Re: Block 2 & 2A PA – Council Letter 17/11/09

Comparison Study: Block 2 Concept Plan and P.A. Models

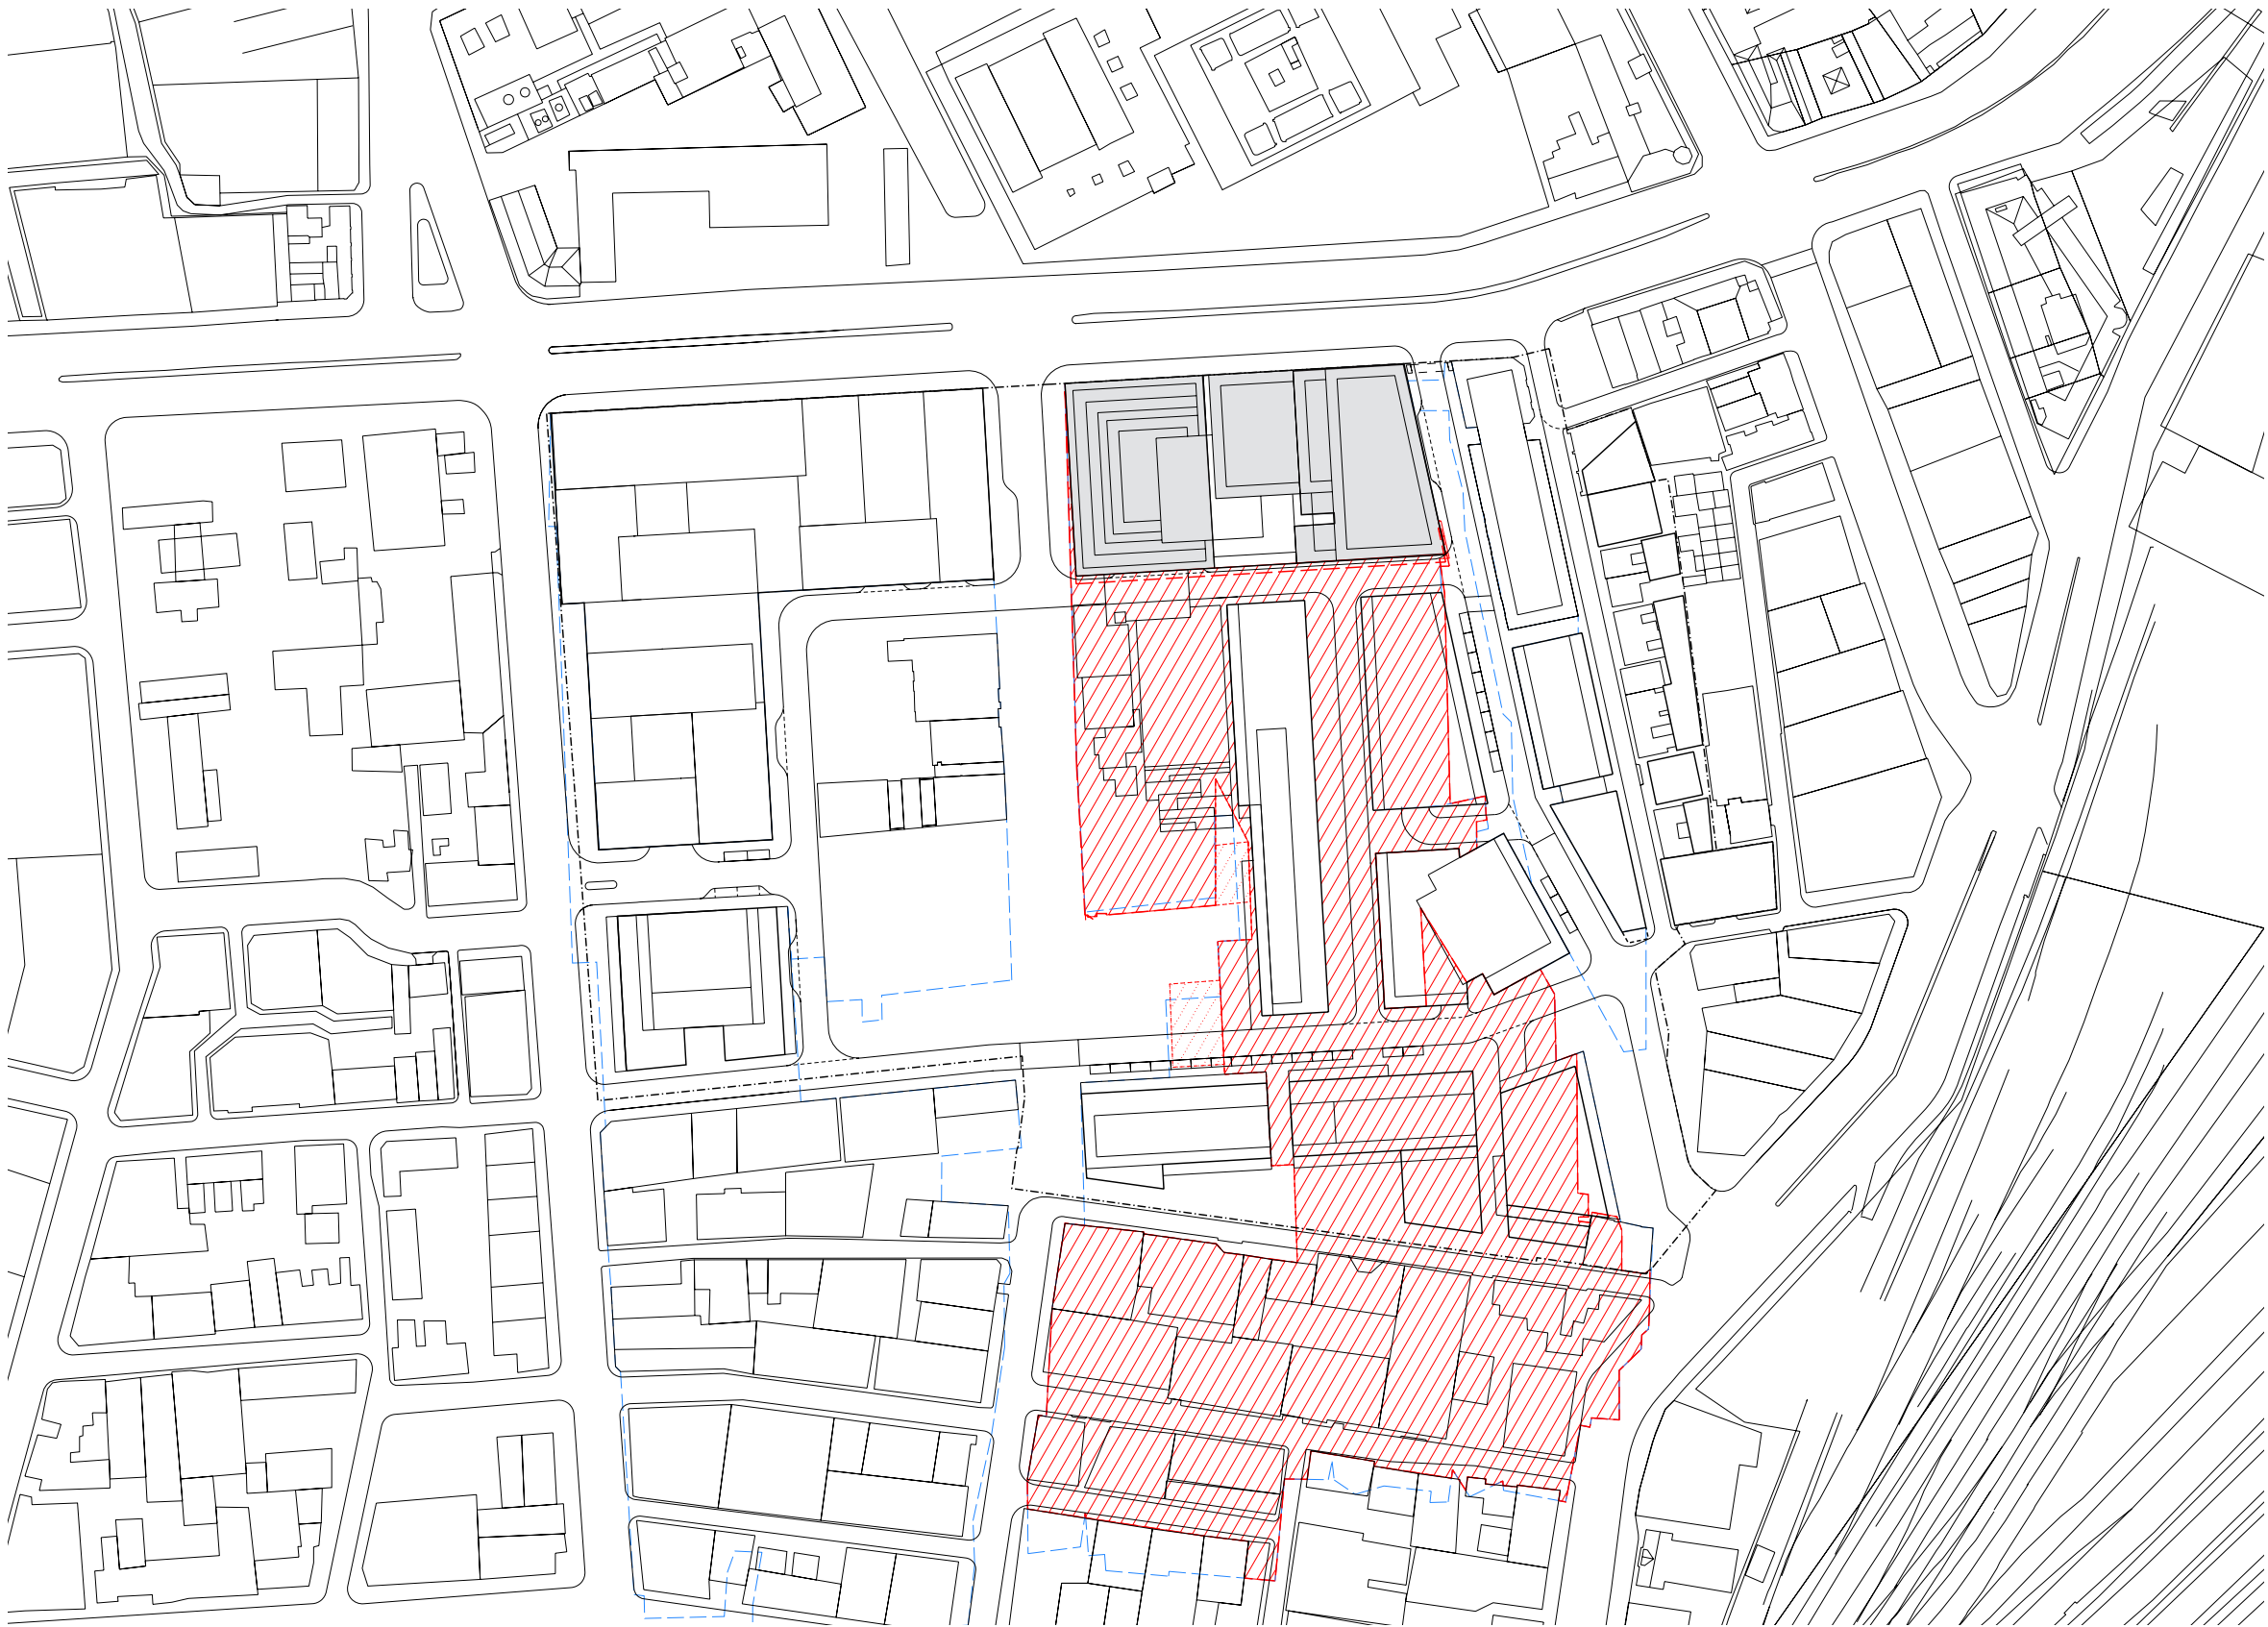
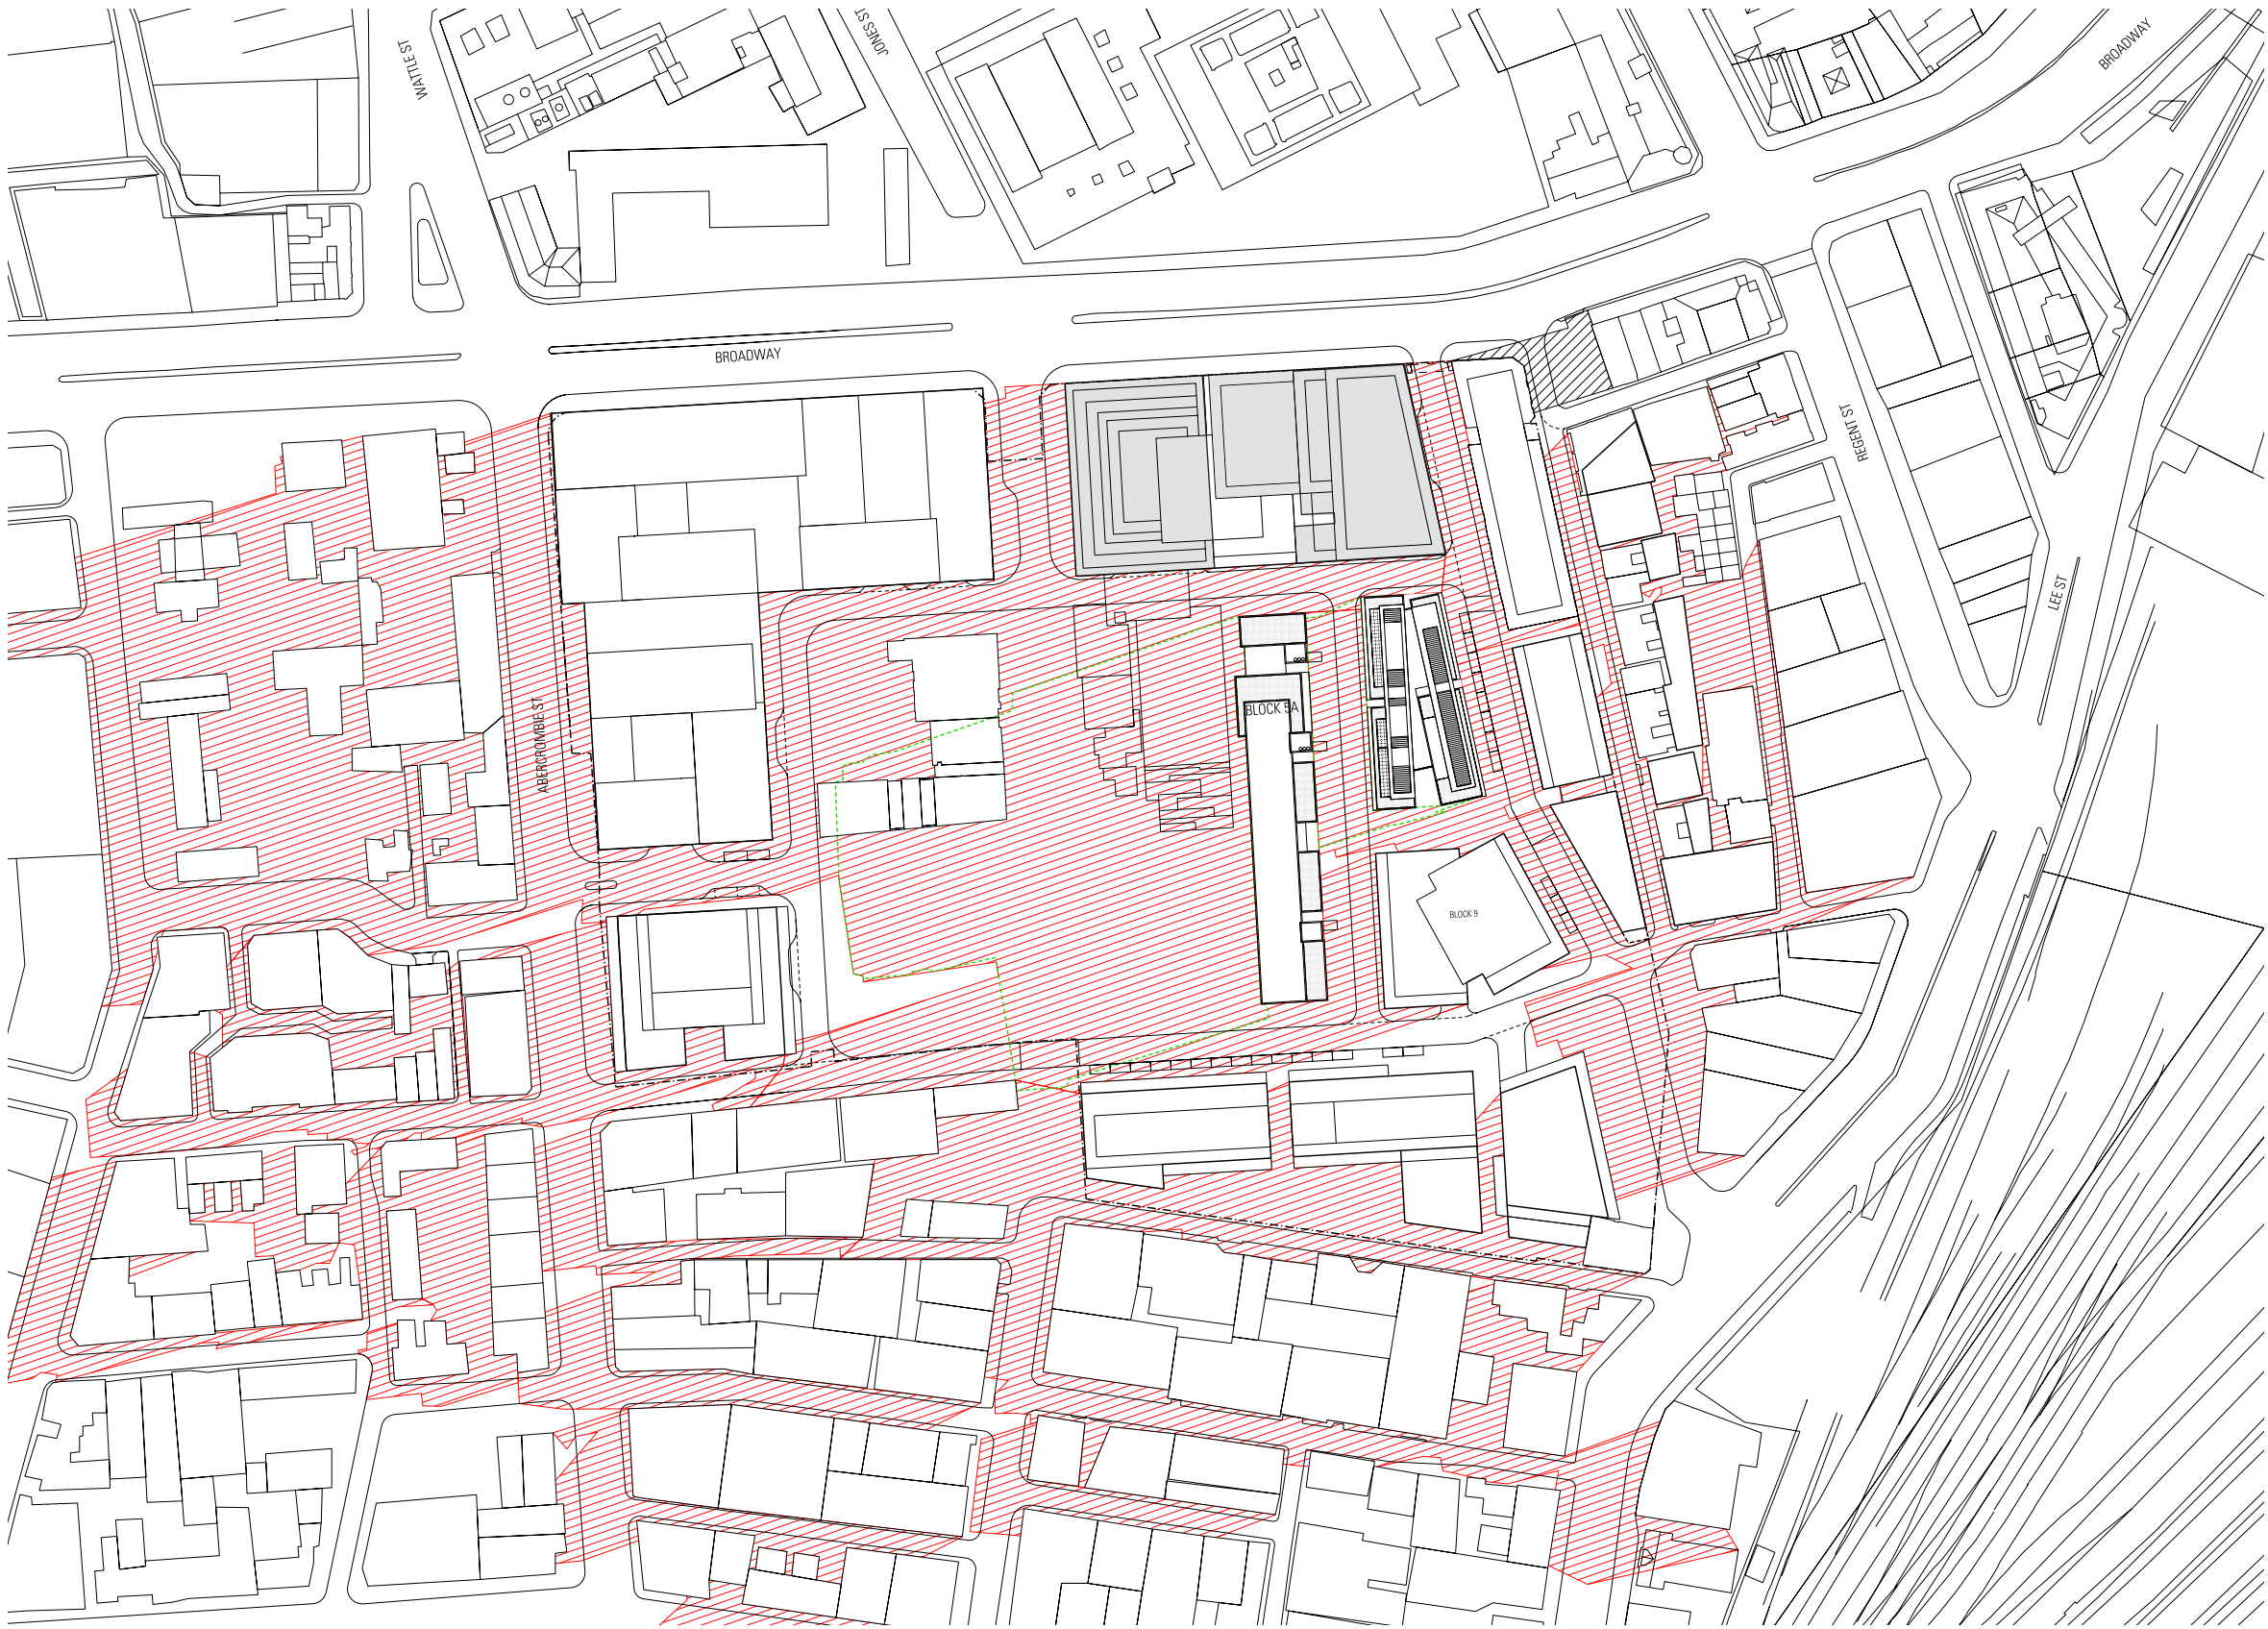
Condition	Approval Authy	Timing	By and Comments
	CoS Letter			
URBAN DESIGN				
Pt1	Height Scale and Massing	Note		This is responded to in the body of the PPR. Frasers and AJN do not accept COS comments.
Pt2	Street Activation	SCC		This is responded to in the body of the PPR. Frasers and AJN do not accept COS comments.
Pt3	Podium Finishes	SCC		This is responded to in the body of the PPR. Frasers and AJN do not accept COS comments.
Pt4	Public Art	SCC	Public Art submission	Frasers have submitted and the City of Sydney has endorsed the Public Art Strategy. The public art proposed for Block 2 will be agreed in principle with the City of Sydney prior to the issue of the CC. Subsequent detailing, procurement and installation will be undertaken in conjunction with the Council who shall provide approval prior to the Occupation Certificate being issued.
Pt5	Portal Finishes	SCC		This is responded to in the body of the PPR. Frasers and AJN do not accept COS comments.
